URGENT – BY HAND

Application FP/140/18/CLP – Mrs R Rae, 5 Old School Mews, PO22 7PT

COMMENT

Proposed
French Door's
@ 5 old School Mew's
Felpham

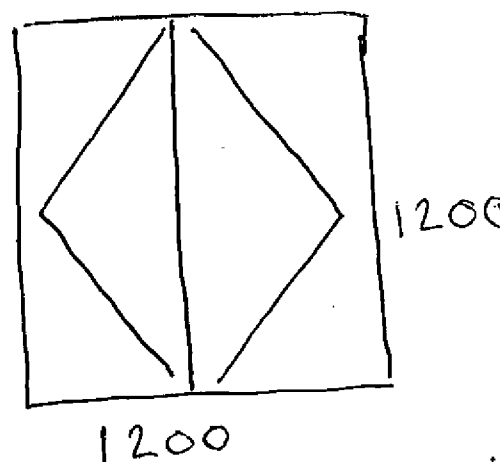
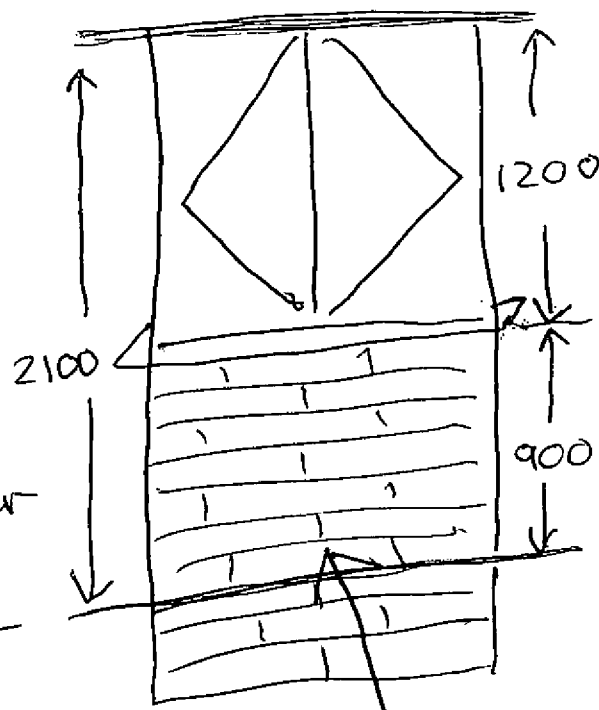
This is a Conservation Area and, in my opinion, French doors at No 5 Old School Mews would not be in keeping with the other properties here.

I don't see it as a very sensible idea and the proximity to the main road would make it very noisy.
